Kevin Cox
Crime Prevention Design Advisor
Thames Valley Police Headquarters South
Oxford Road
Kidlington
Oxfordshire
OX5 2NX

REF: 23/02715/REM

Location: Land North Of Bicester Avenue Garden Centre,
Oxford Road, Bicester

28 November 2023

PROJECT BICESTER ARC - PLOT 1 - OFFICE BUILDING	
TITLE CYCLE STORE & BINS

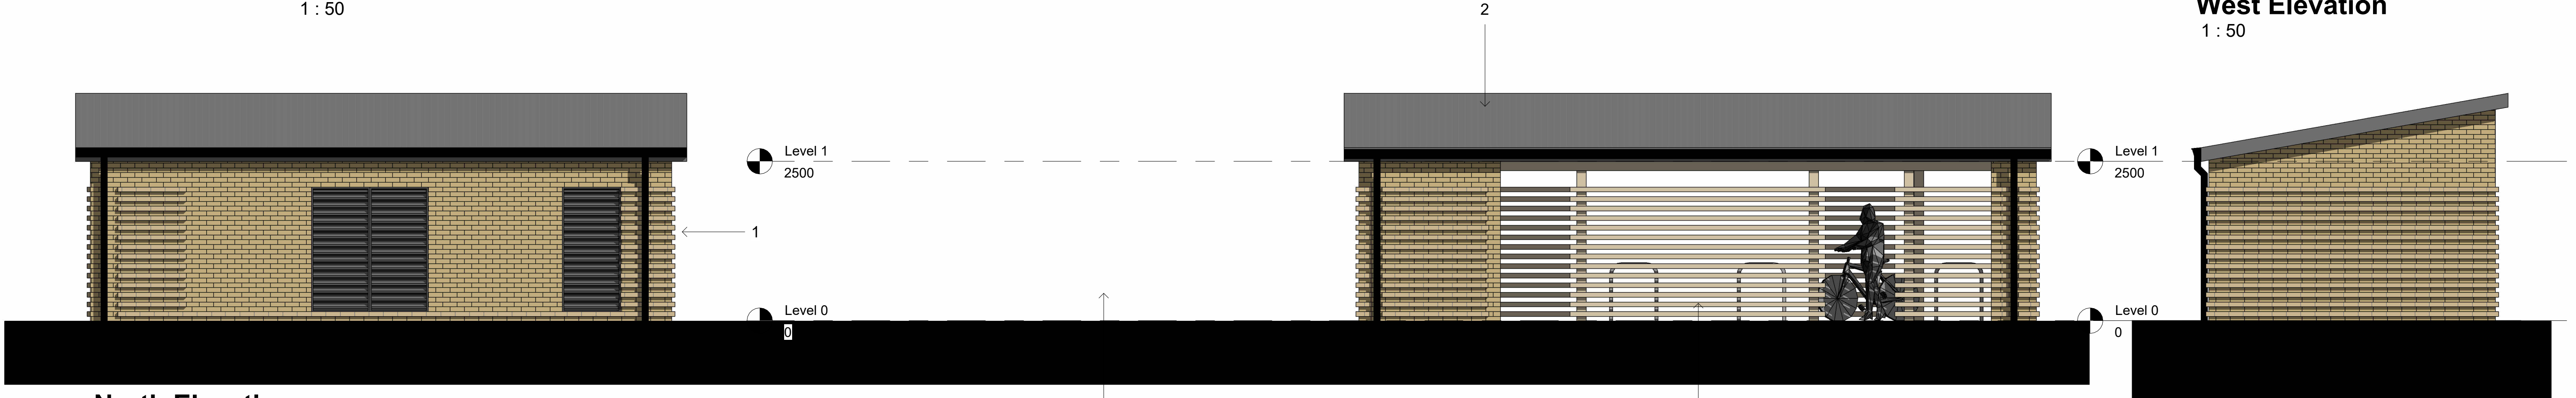
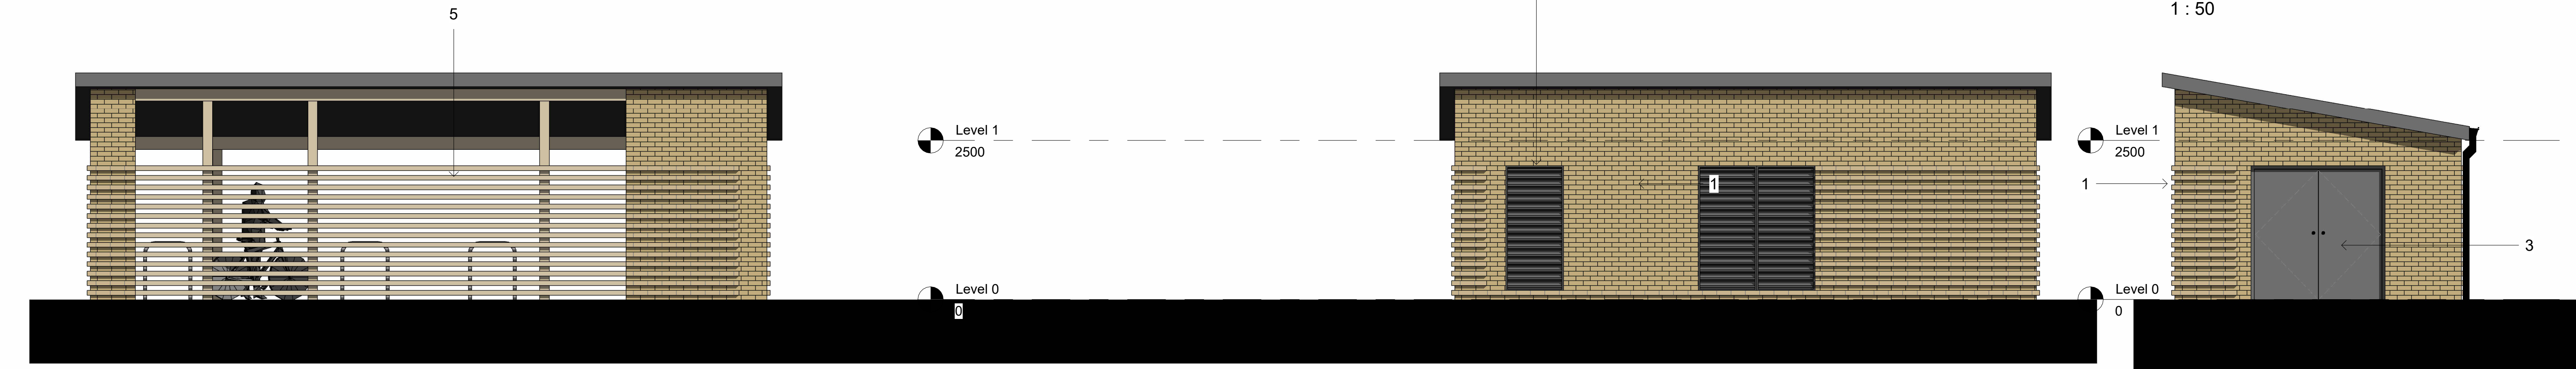
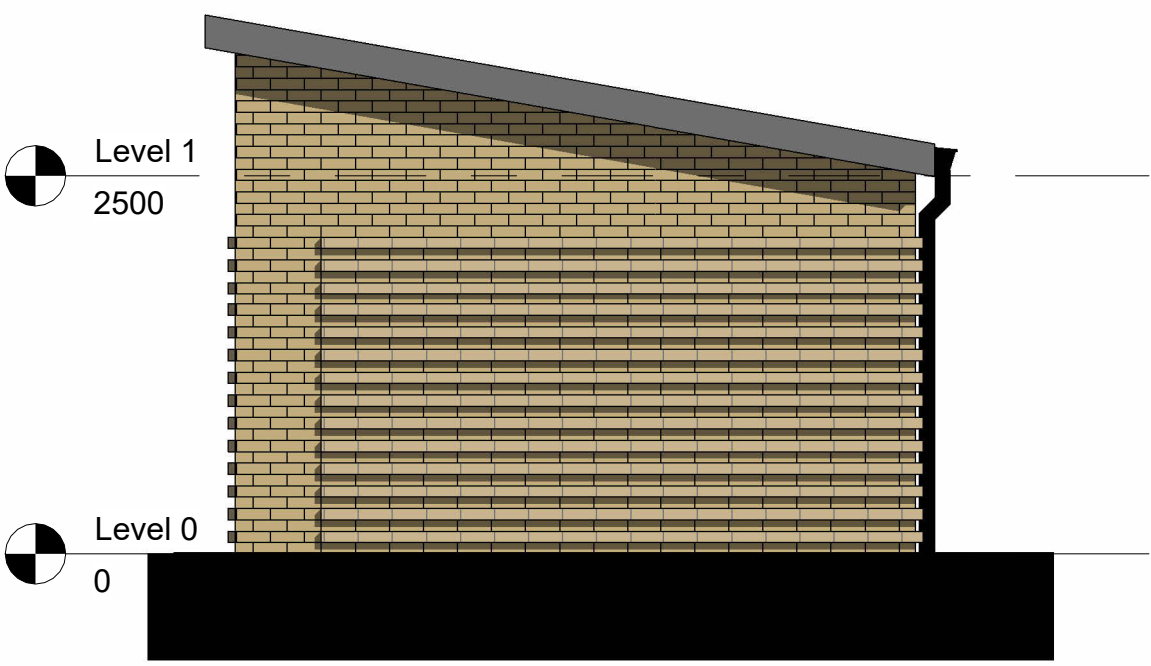
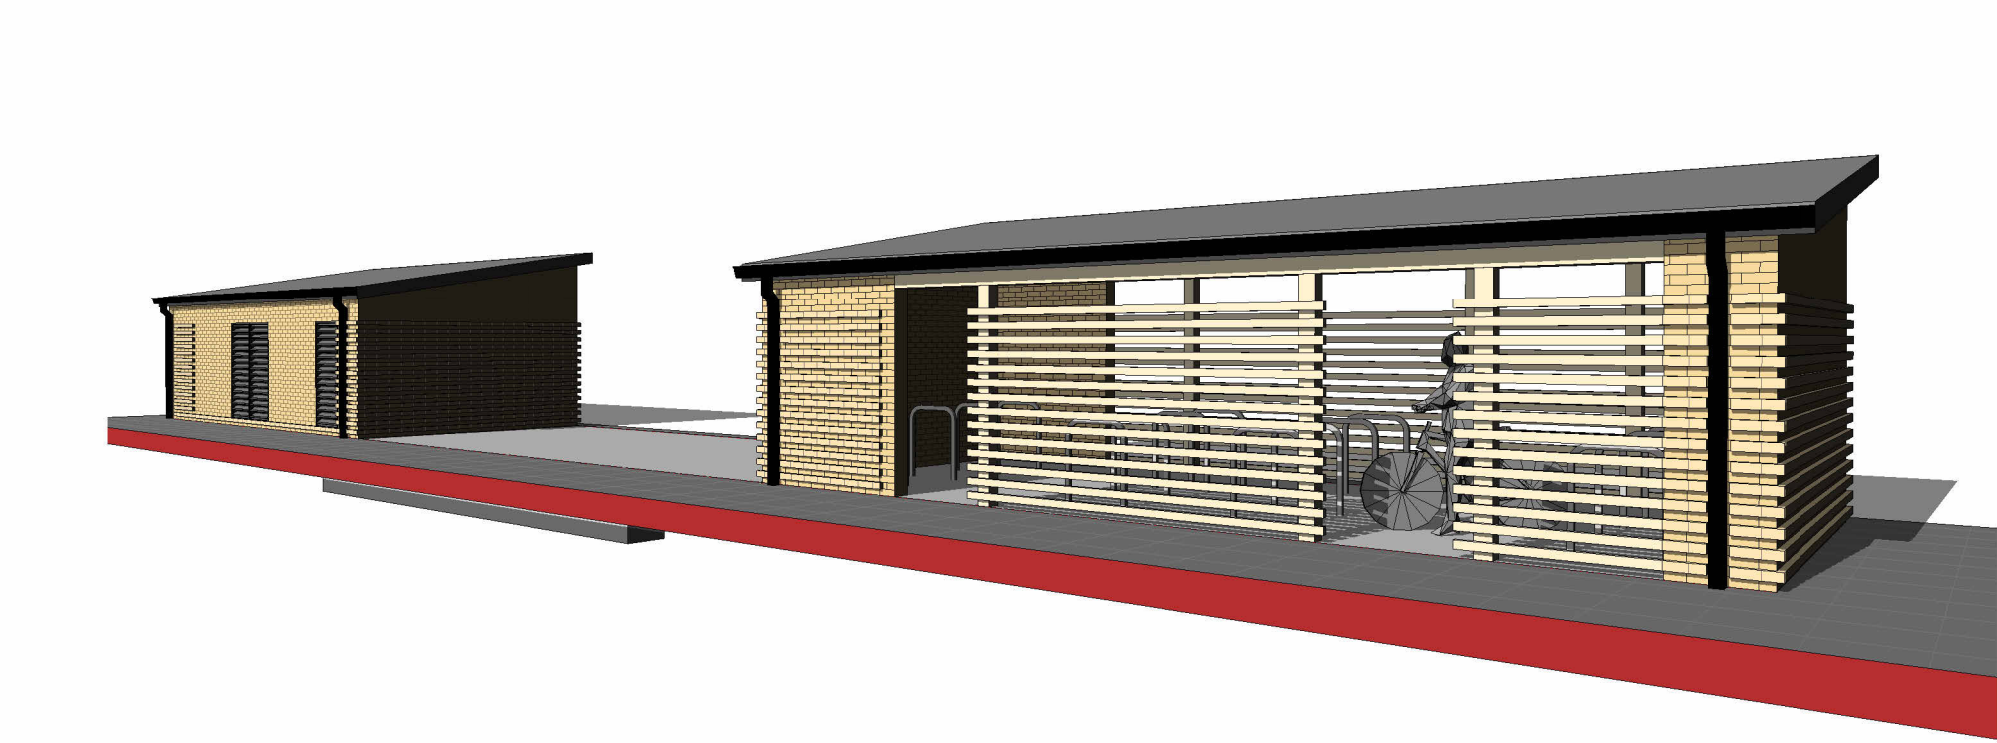
- I recommend the large cycle store is secure, enclosed and access controlled in accordance with the guidance of Secured By Design. The current proposed design enables an offender to gain unhindered access to cycles without the risk of being seen.
- Cycle storage facilities should be covered by CCTV and be lit.
- Depending on the nature of waste being stored, it may be necessary for the bin stores to have enhanced security secured to LPS 1175 SR2/B3. Enclosures should be fully covered by CCTV.
